From: Bruce Taunton
Sent: 04 June 2010 14:34
To: Planning.Responses
Subject: RE: Planning Consultation on: WA/36/10/

APPLICATION WA/36/10/
NO:

Description of Works: Retrospective application for the retention of boundary fence and proposed replacement of the main gate.

ASHURST
BINSTED LANE
BINSTED BN18 0LPtitle PLANNING APP FOR WALLS /
FENCE ON BINSTED LANE

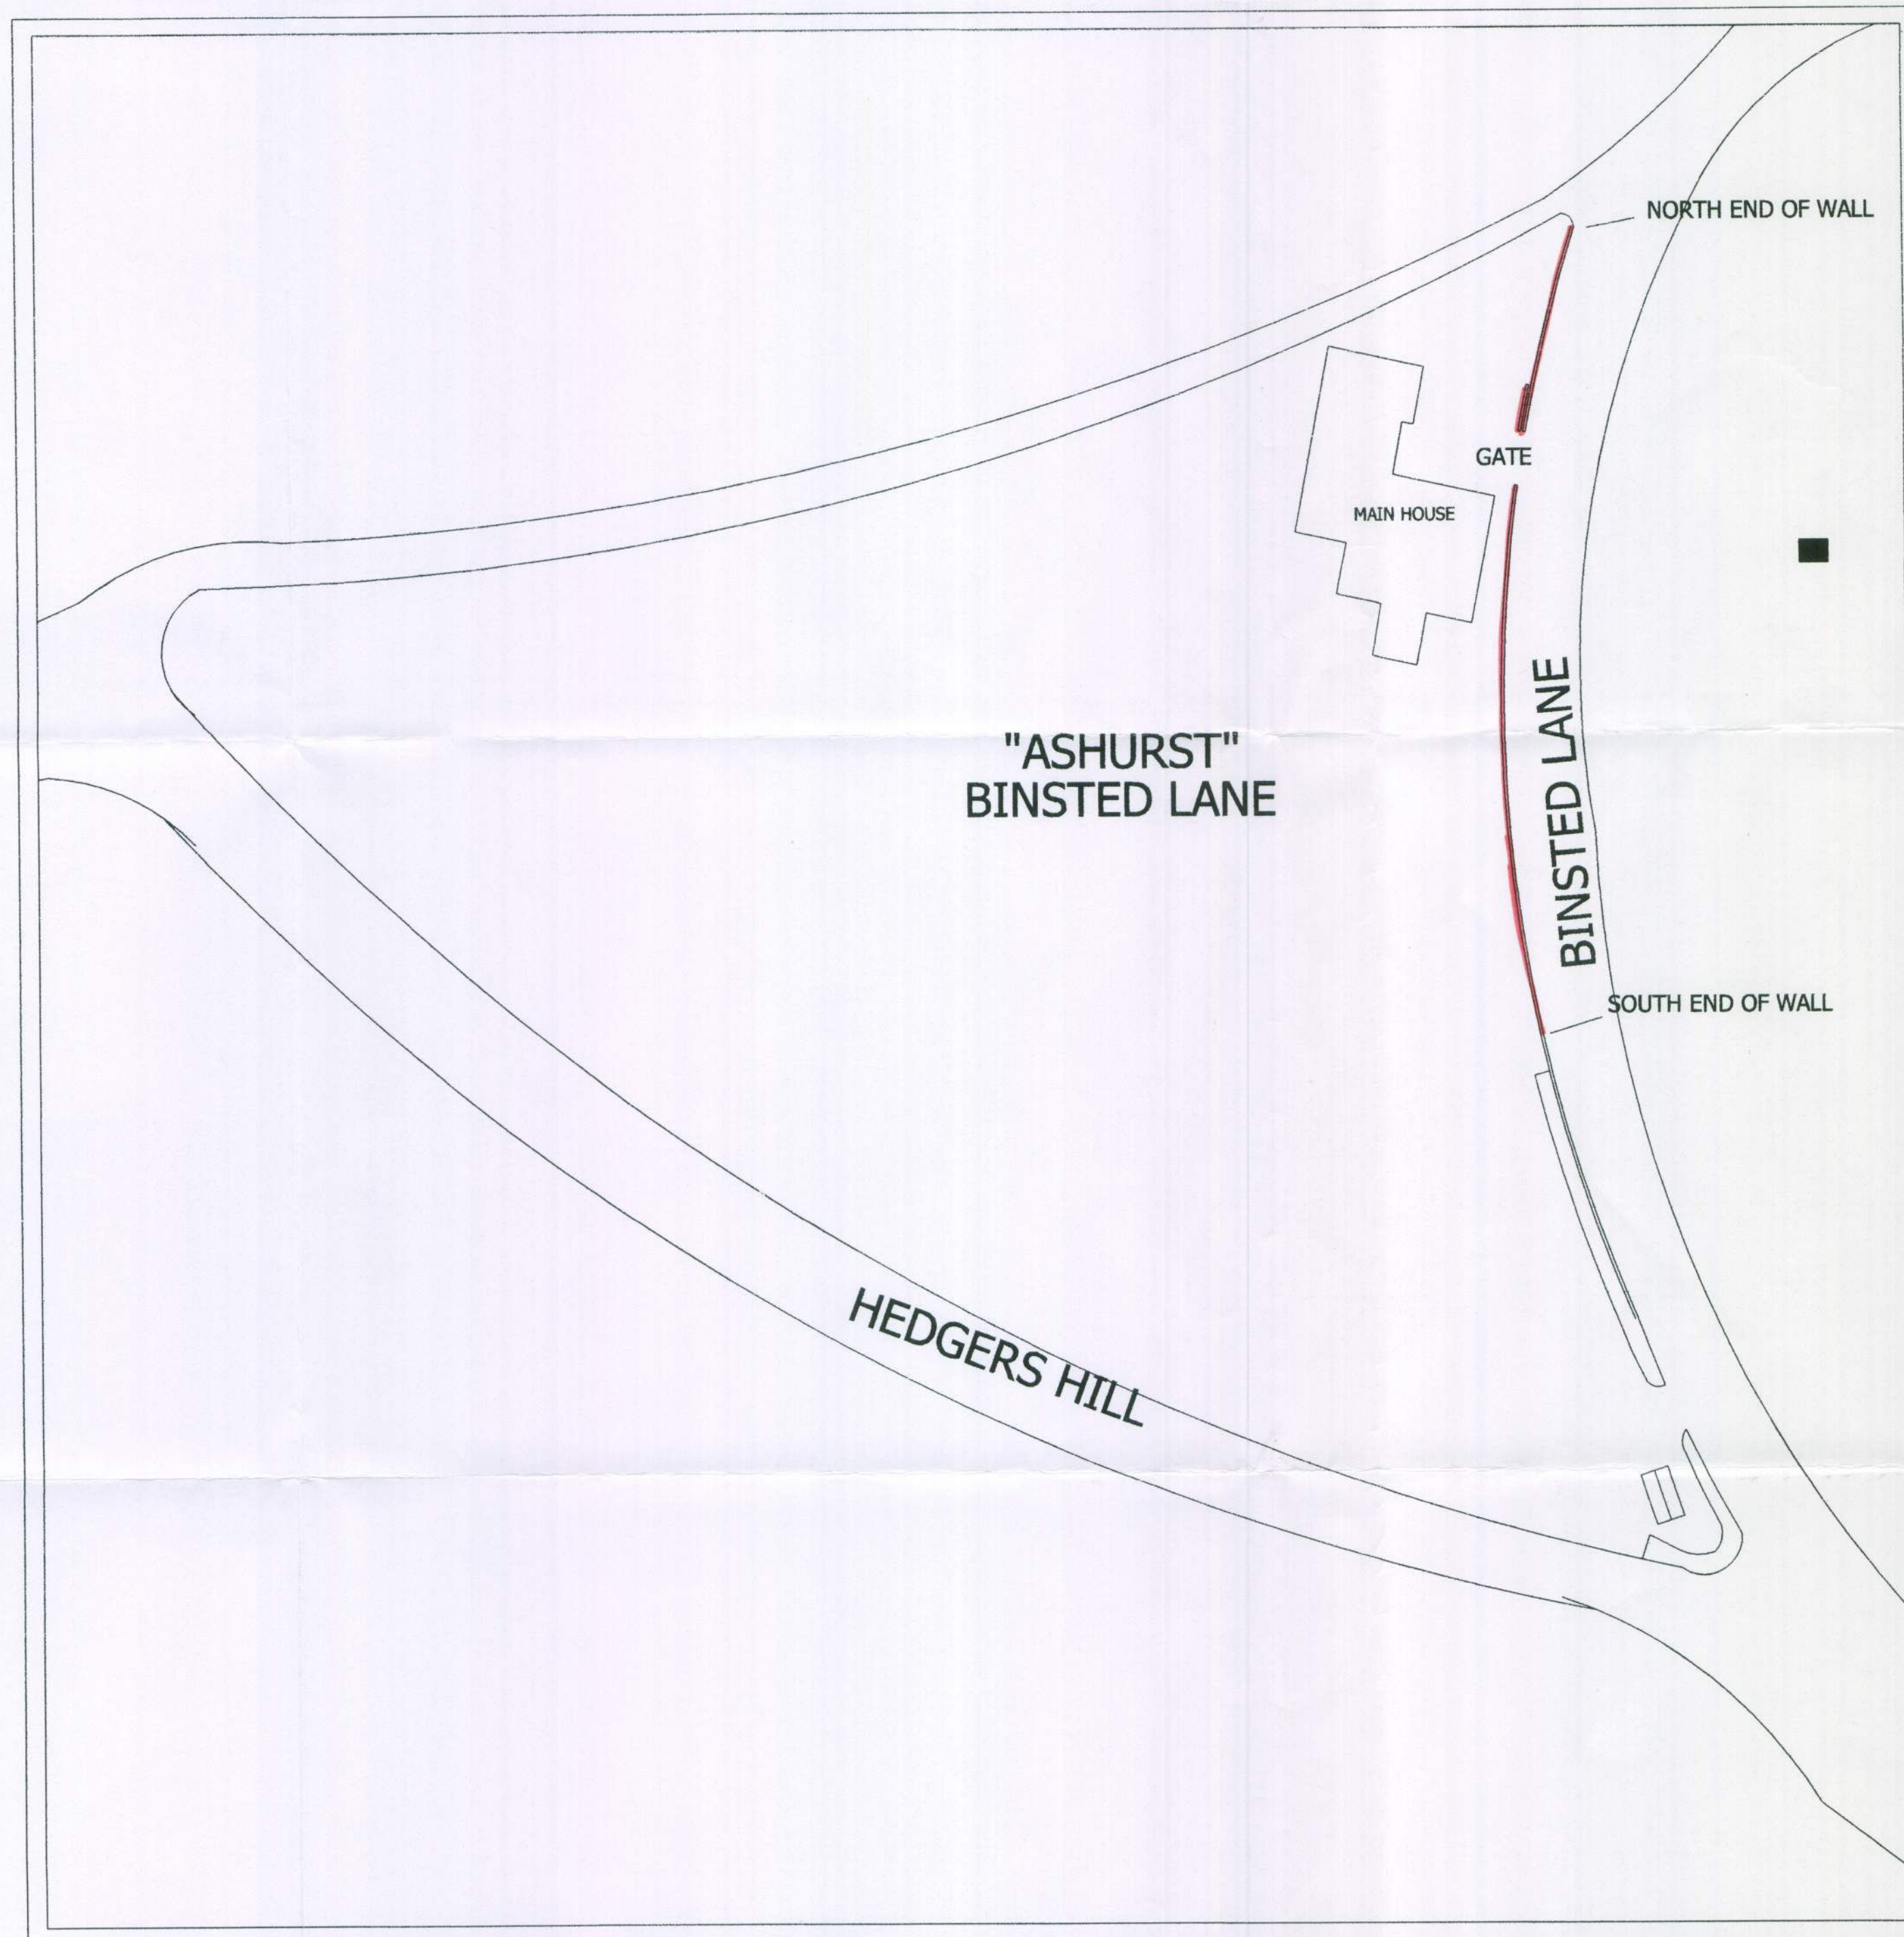
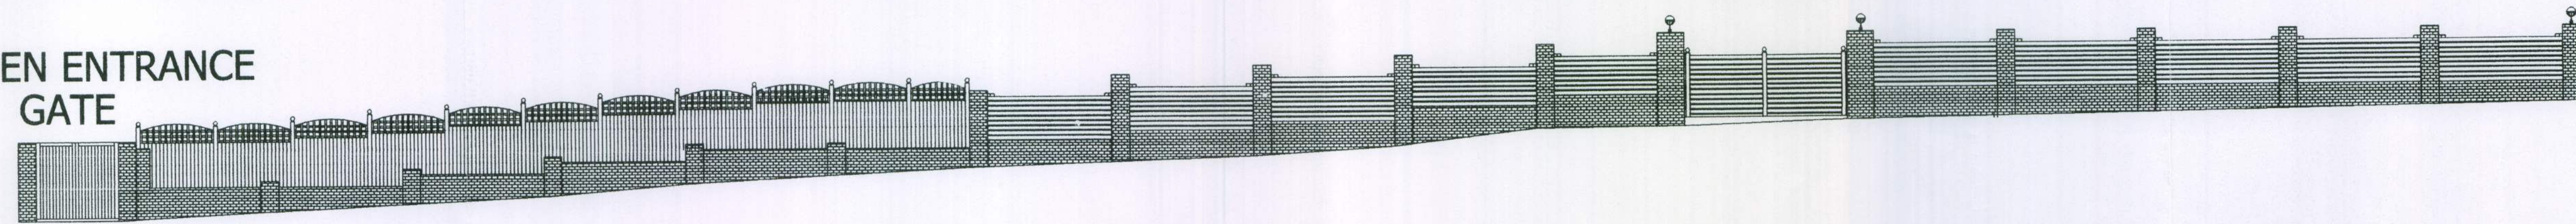
Please provide structural calculations to justify the stability and strength of the piers for lateral wind forces.
